Eastergate Parish Council
Mr GR Sleet
12 The Cedars
Barnham
Bognor Regis
PO22 0EZ

Your Ref:
Our Ref: EG/33/11/
Please ask for:
Mr J Baeza

Proposed redevelopment of land to provide 13 no. new dwellings to include 4 no. 2 bed houses, 6 no. 3 bed houses, 1 no. 4 bed house & 2 no. 5 bed houses. Together with associated access, car parking, landscaping & retention of existing property
Greenoaks Barnham Road Barnham

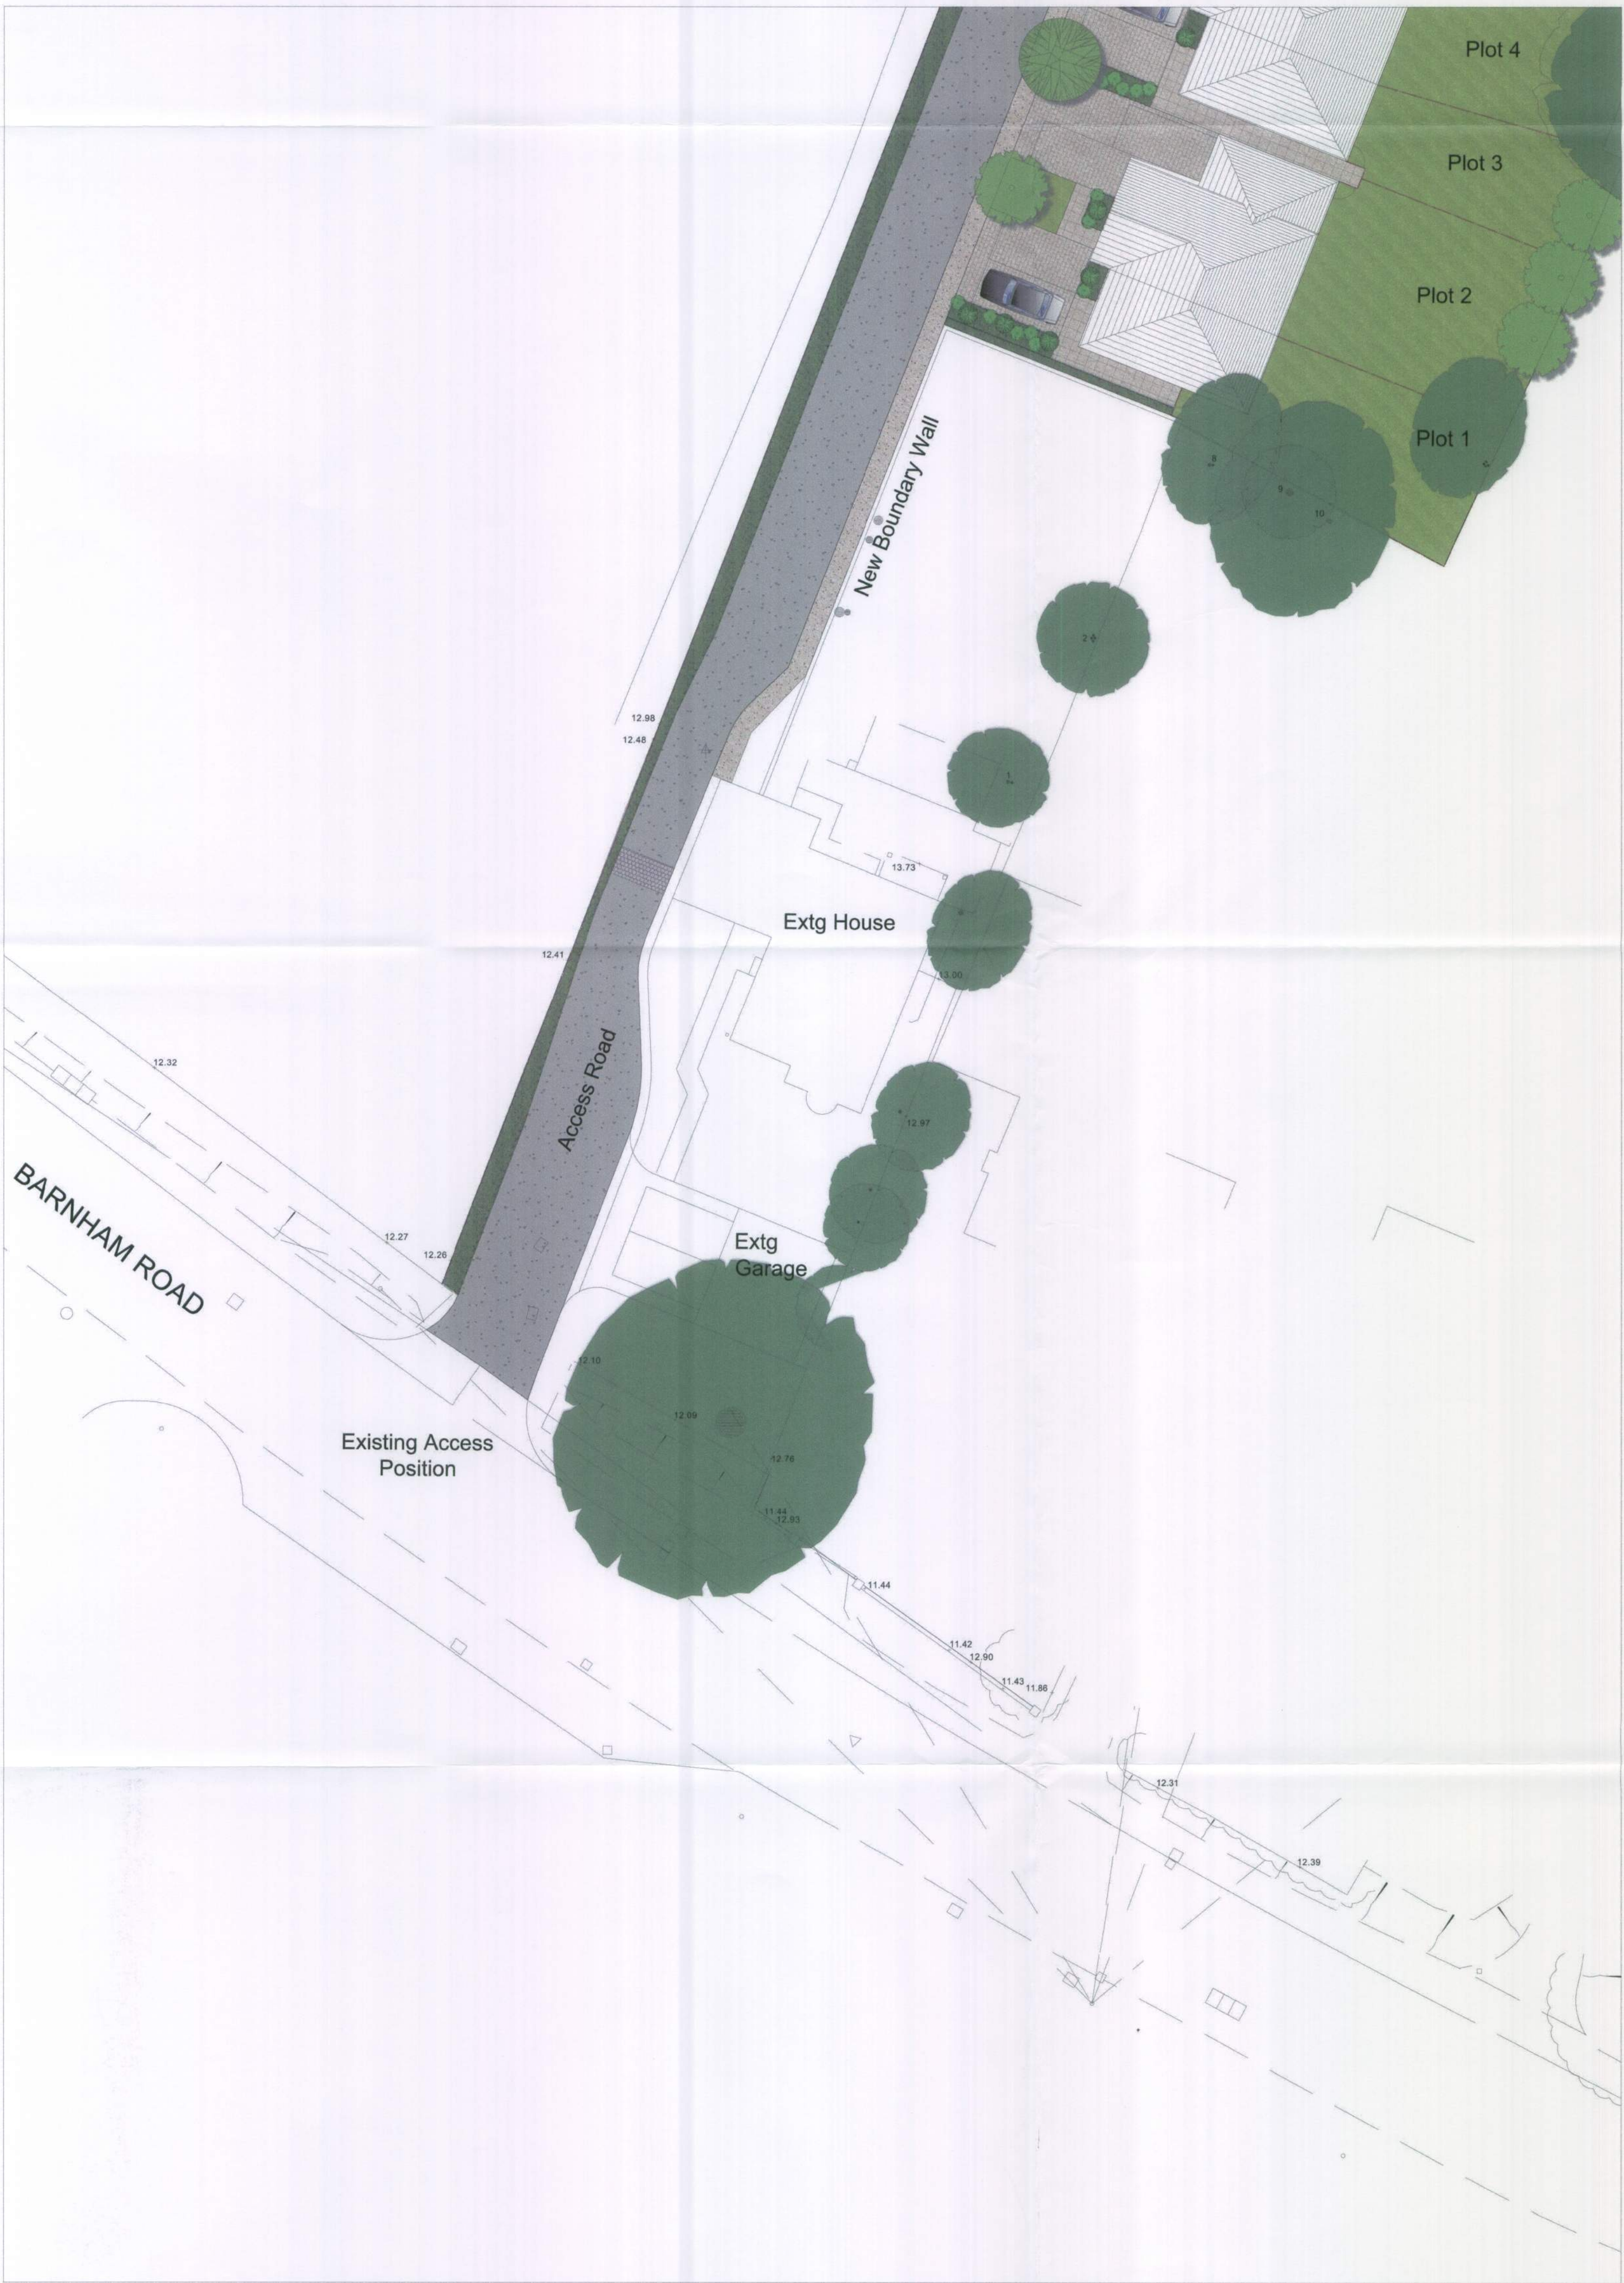
The Parish Council reiterates its previous objections in response to earlier applications. In addition, the council expresses concern as to the altered accessway route onto Barnham Road. This is likely to produce a hazard given the busy nature of this single lane "B" road. The council also considers that the change to semi-detached housing is out of keeping with the locality and other roadside properties. The removal of the "tree screen", which appears to be proposed, would be contrary to the Inspectors conditions applied to an earlier Appeal.
